**SSD-14757962 for Peninsula Solar Farm at Paytens Bridge Road, Forbes NSW
Lot 441 DP 1124885, PT Lot 442 DP1124885 and PT Lot 9 DP752938**

26 October 2022

TfNSW has reviewed the information provided, including a *Traffic Impact Assessment*, prepared by Impact Traffic Engineering Pty Ltd, dated 24 August 2022 and the *Environmental Impact Statement*, prepared by Accent Environmental Pty Ltd dated 5 September 2022, and is not satisfied that the proposed development has adequately addressed the anticipated construction traffic impact on the classified road network. Accordingly, TfNSW does not support the application as proposed.

Figure 16. Road and Rail Network in Local Surrounds

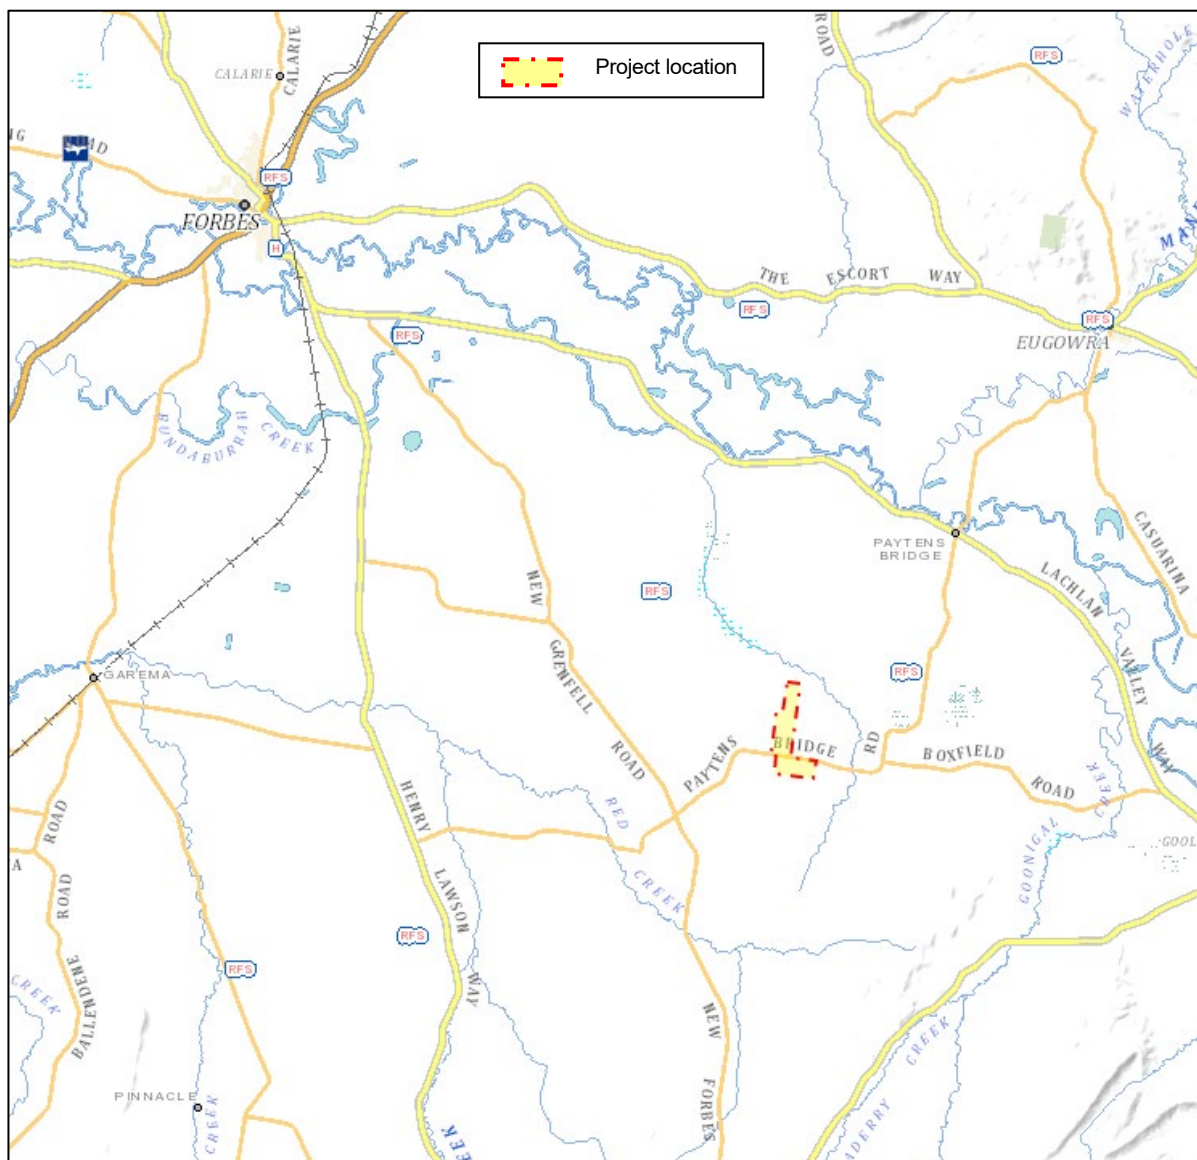
An assessment of the likely transport impacts to the site access route (including, but not limited to, Paytens Bridge Road, New Grenfell Road, Lachlan Valley Way, Hume Highway, the Newell Highway and the Stockinbingal-Parkes railway line), site access point(s), any Crown land, particularly in relation to the capacity and condition of the roads, road safety and intersection performance.

This matter must be addressed in a revised TIA.

- The traffic impact of the road only route identified as the 'second alternative / secondary access' in the TIA needs to be assessed in more detail, including (inter alia) the impact on traffic and road safety on the classified roads. Consideration should be given to providing a road safety assessment of the key haulage route, identifying any weight limits on the route and identifying necessary intersection upgrades (as required).

- It is understood that all three of the proposed haulage routes includes transportation via Lachlan Valley Way (HW56). Traffic counts are required for Lachlan Valley Way, north and south of Paytens Bridge Road, including a peak hour intersection traffic count at the intersection of Lachlan Valley Way and Paytens Bridge Road.
